PLANNING AND COMMUNITY DEVELOPMENT DEPARTMENT
CRAIG DOSSEY, EXECUTIVE DIRECTOR

July 1, 2020

County File: OAR-20-035

Re: Woodmen Valley Chapel

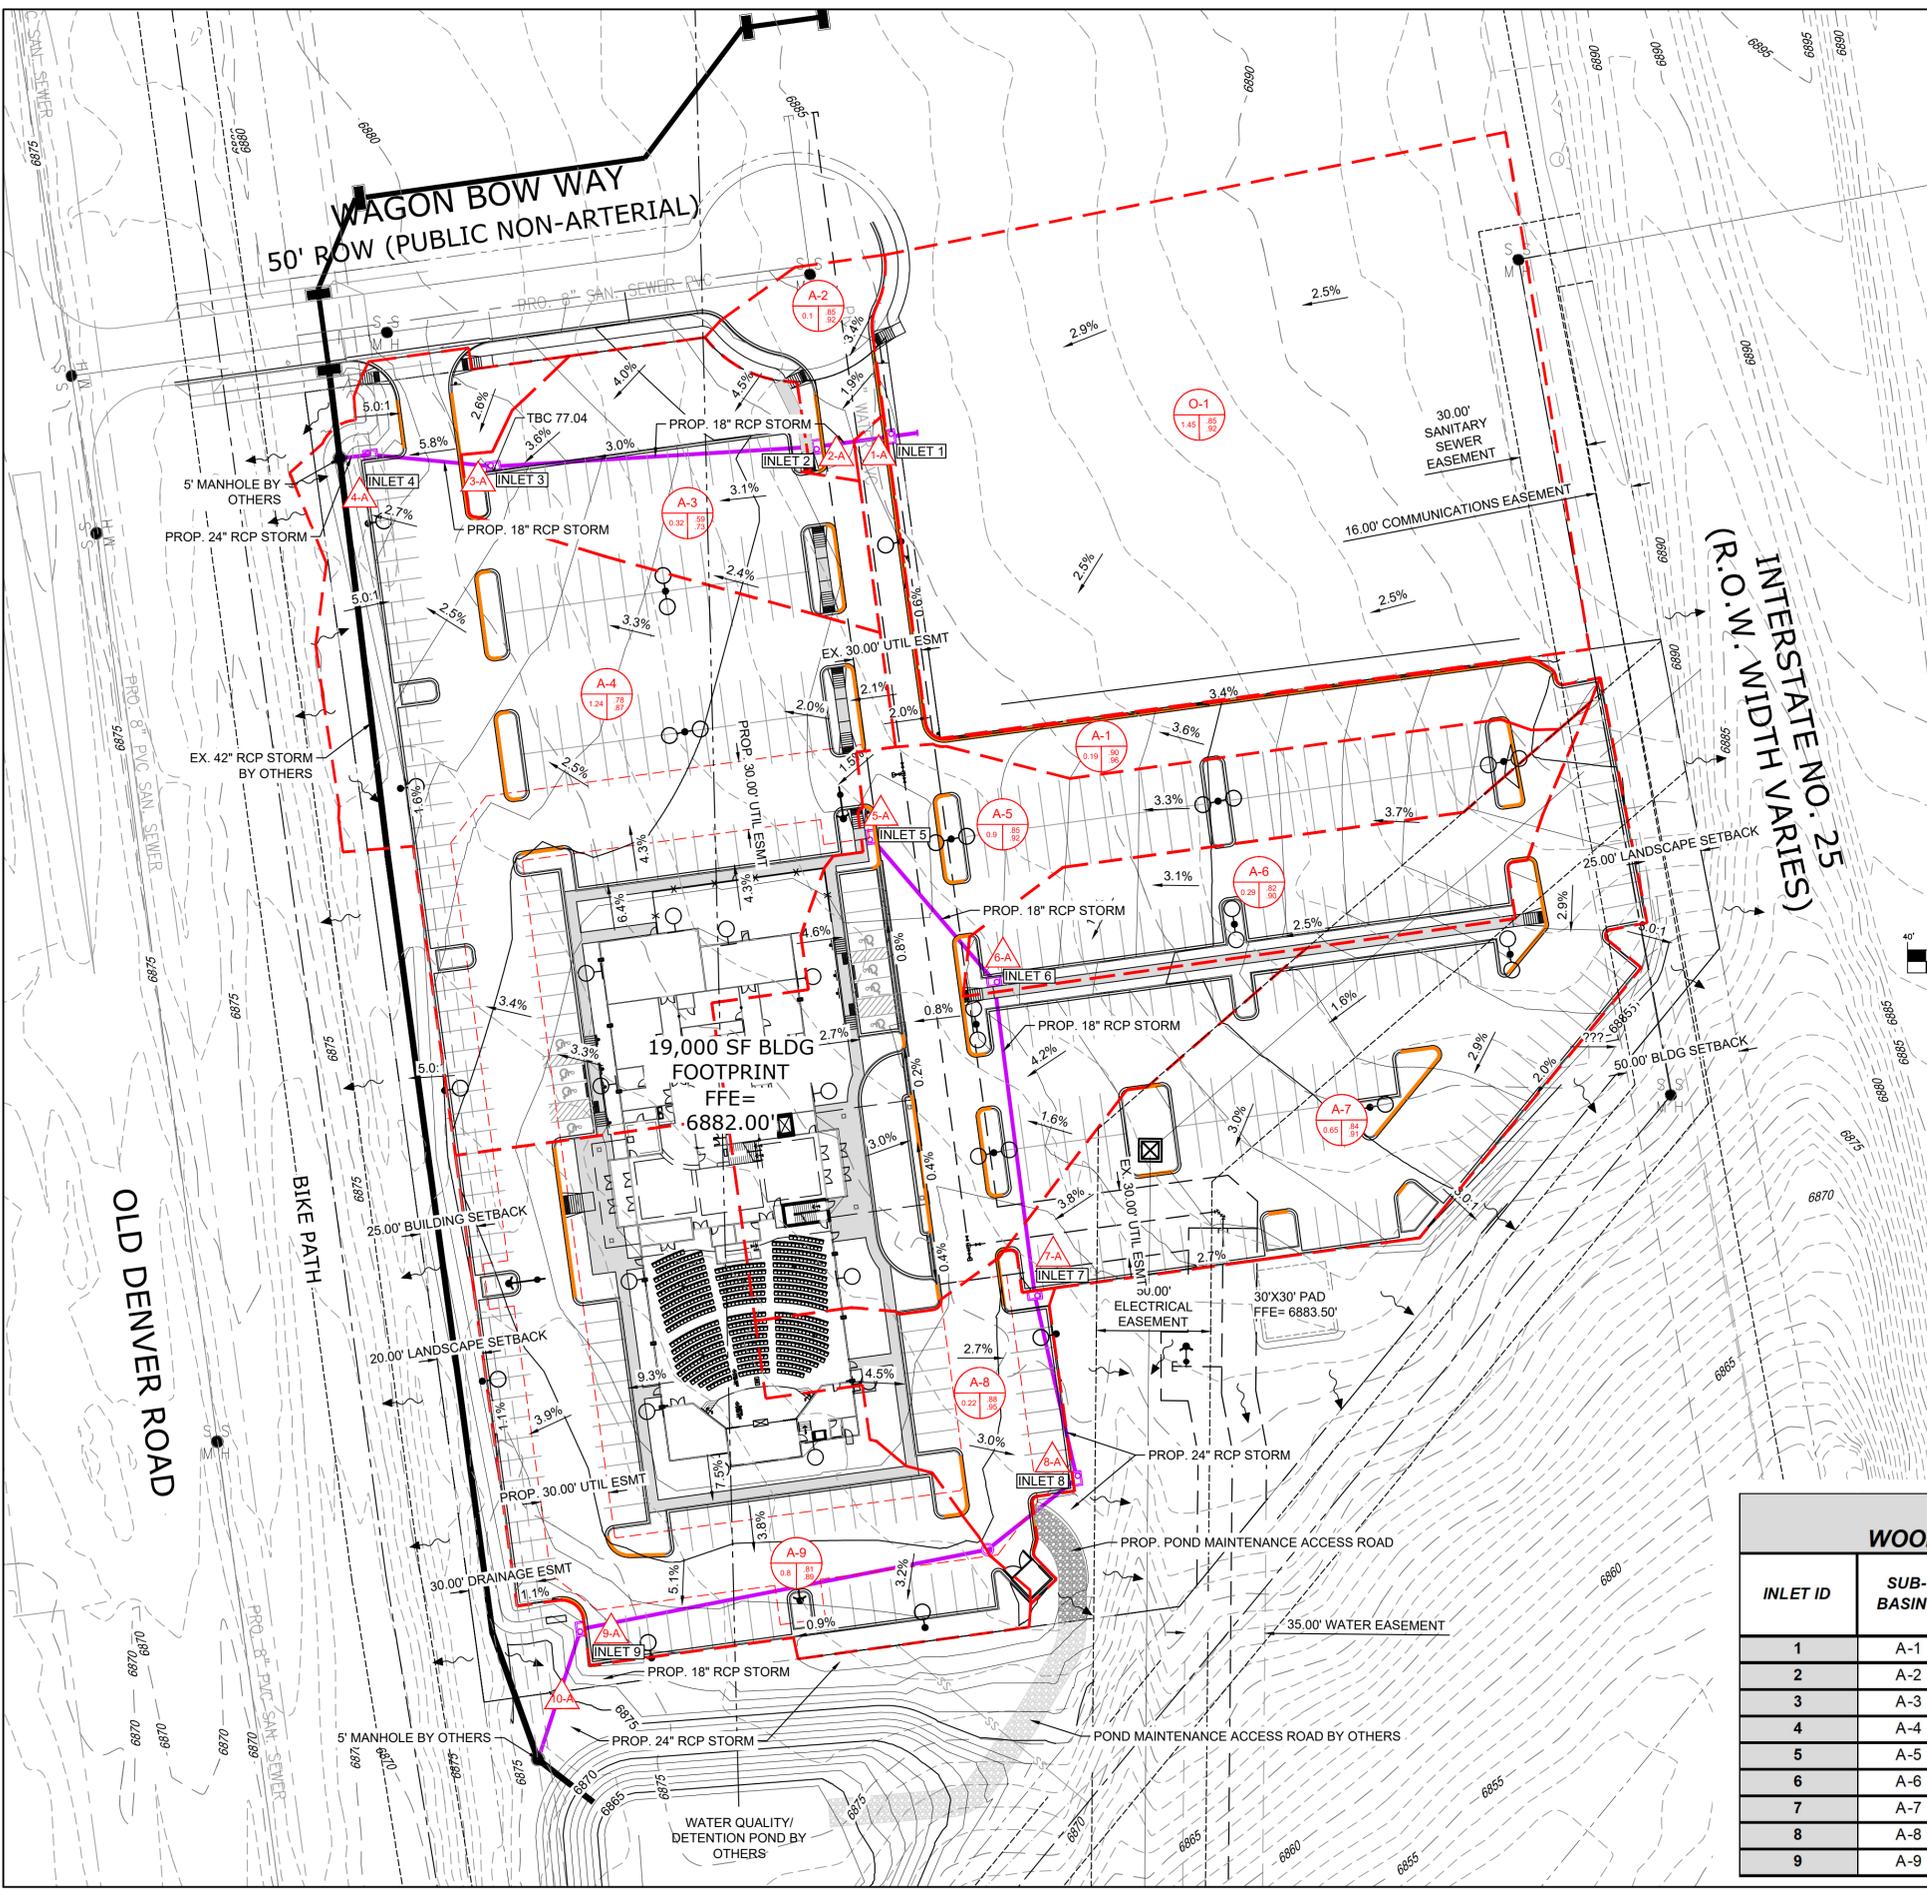
1. Drainage flows into a planned extended detention basin located in the Town of Monument. The drainage report noted an addendum to the Conexus Business Park Drainage Report will be prepared by a different engineer under a different project. County requests the Town provide a copy of the addendum drainage report for review.

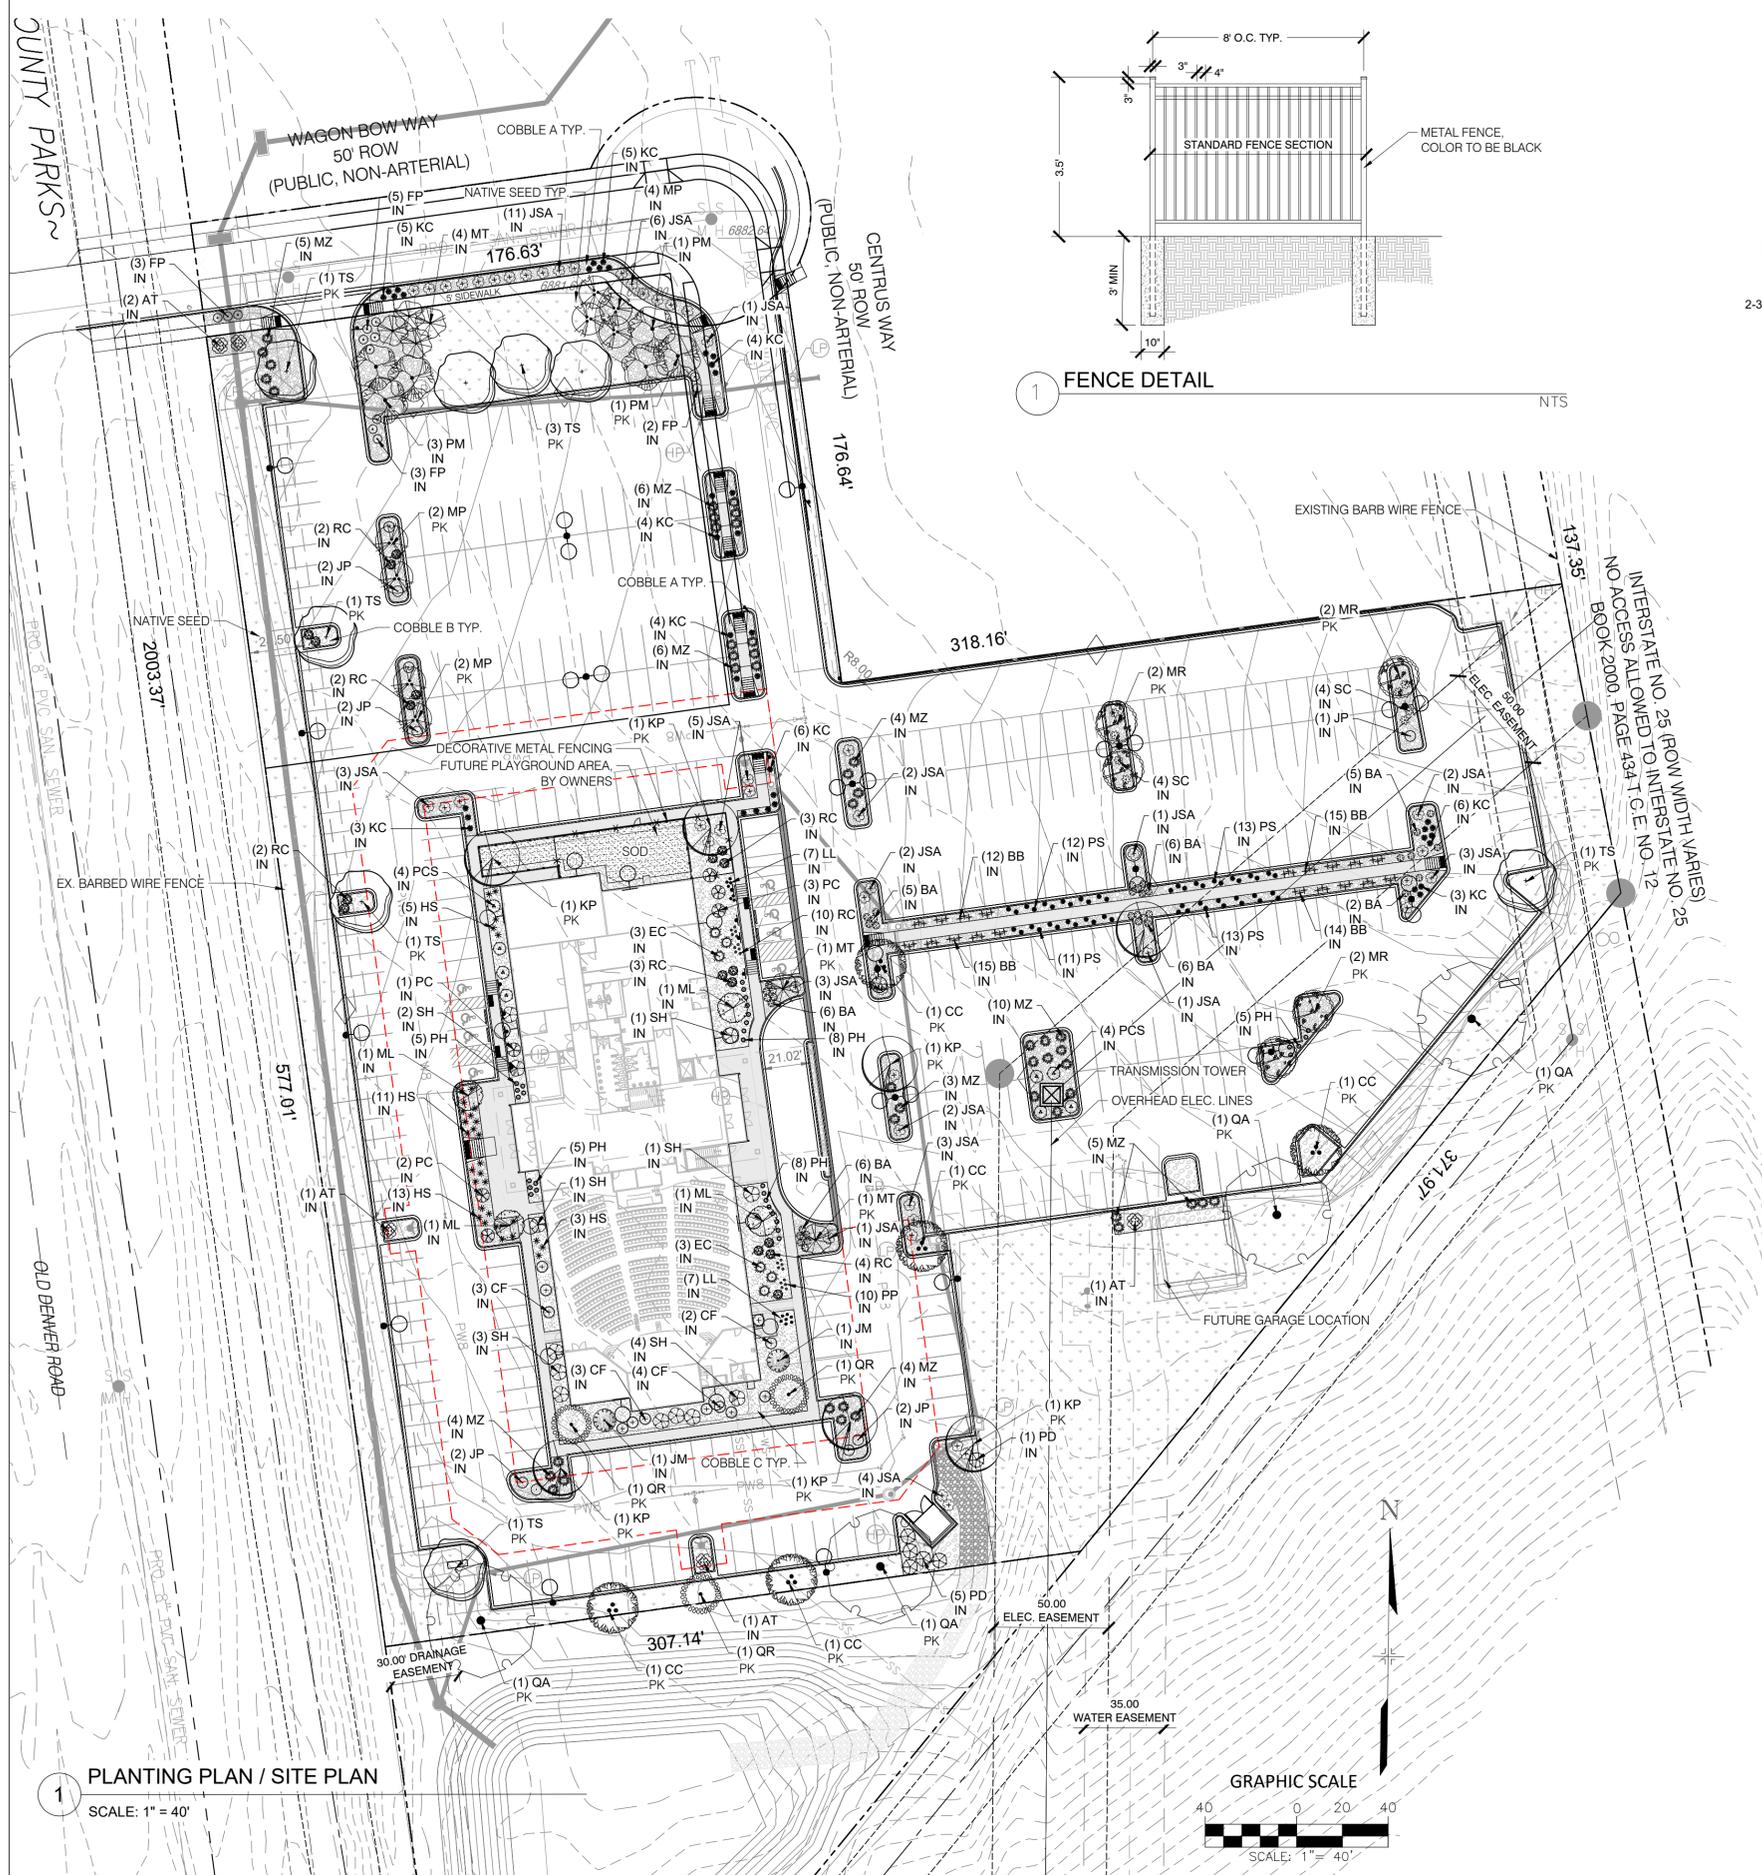
1. No landscaping or buffering has been provided, please provide screening for the development along I-25. Refer to the Tri-Lakes Comprehensive Plan (2000) for information regarding development standards along the I-25 Corridor. The plan can be found at <https://planningdevelopment.elpasoco.com/resources-and-references/#1516982531779-52cc0e87-01af>.
